PAGHAM PARISH COUNCIL

12th September 2019

Re: P/70/19/RES – Land north of Summer Lane, Pagham. Approval of reserved matters following outline consent P/58/15/OUT for 90No dwellings. Also seeking to address the terms of planning conditions 6 (phasing), 8 (ecology), 9(surface water), 12 (vehicular access), 15 (parking), 18 (Travel Plan), 20 (Landscape Management), 24 (Parking Control), 25 (Dwelling parking) and 26 (materials)

Final Site Plan

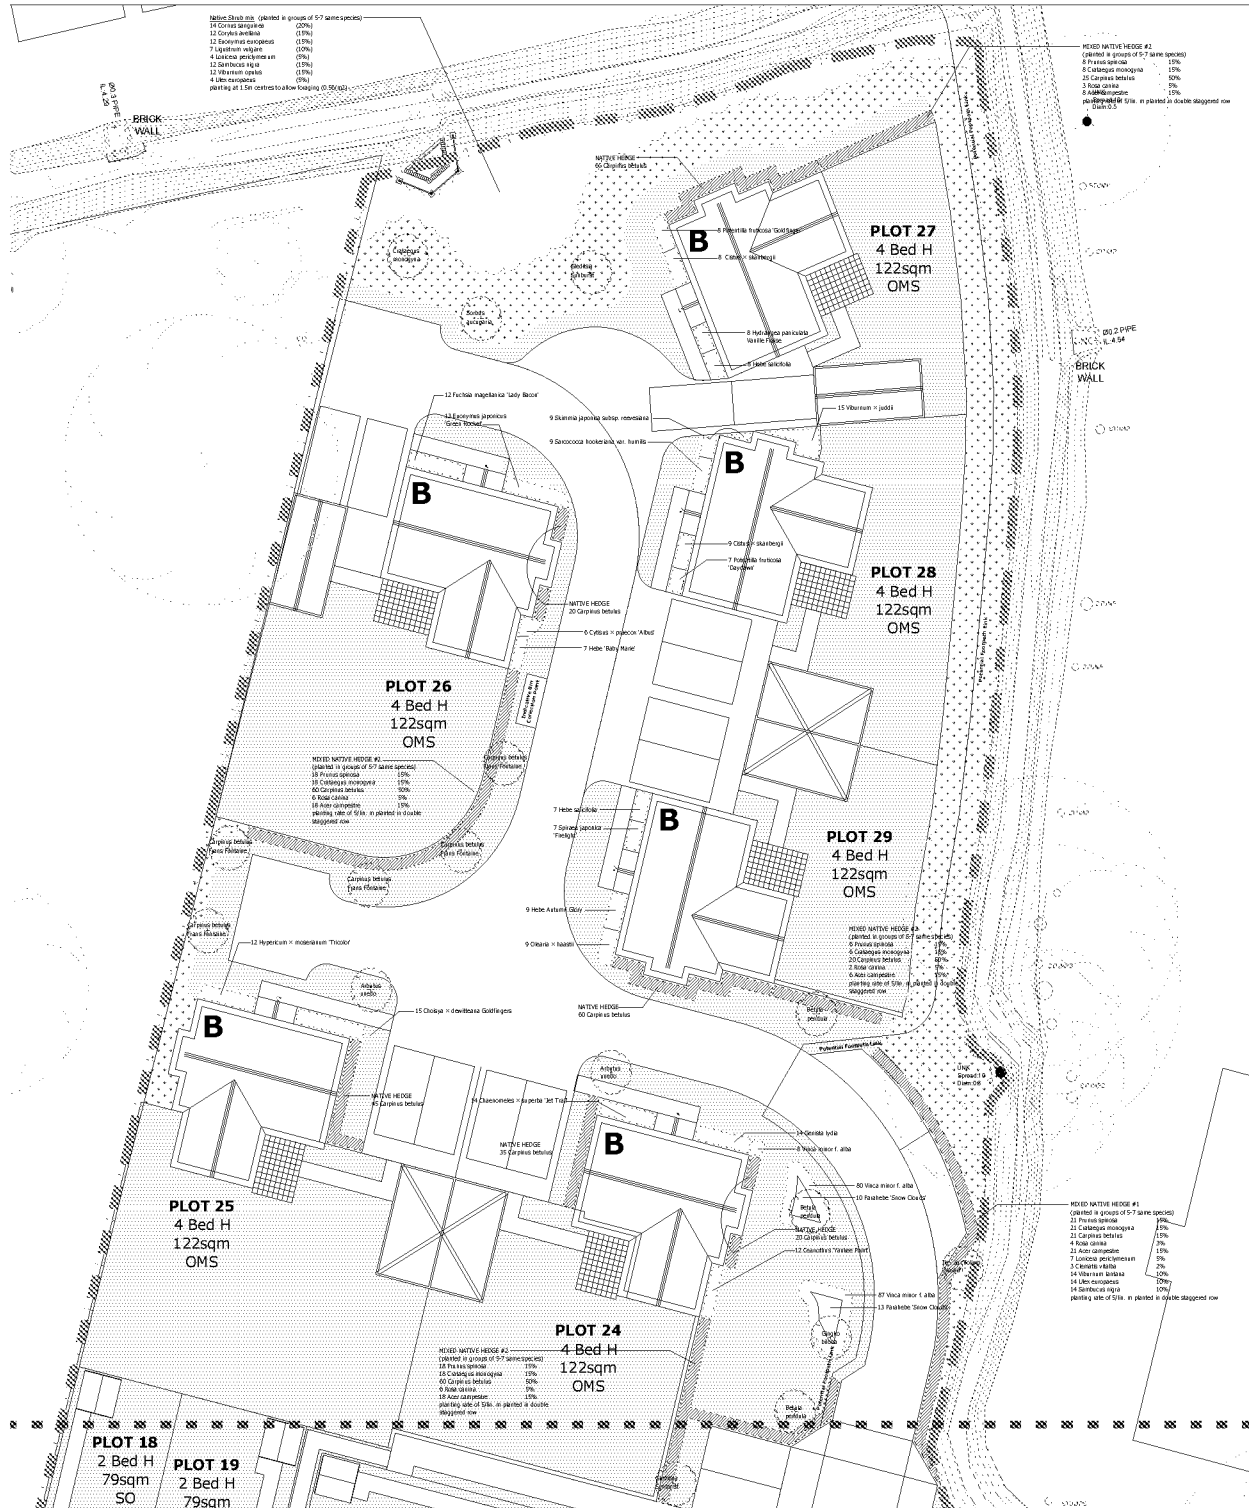
Plots 34/35 and 36/37 are too close to the boundary of the site and will be overbearing to the properties located at Brooks Close, Pagham. This is considered unneighbourly and will lead to loss of light. This is contrary to policy DDM1 Arun Local Plan 2018.
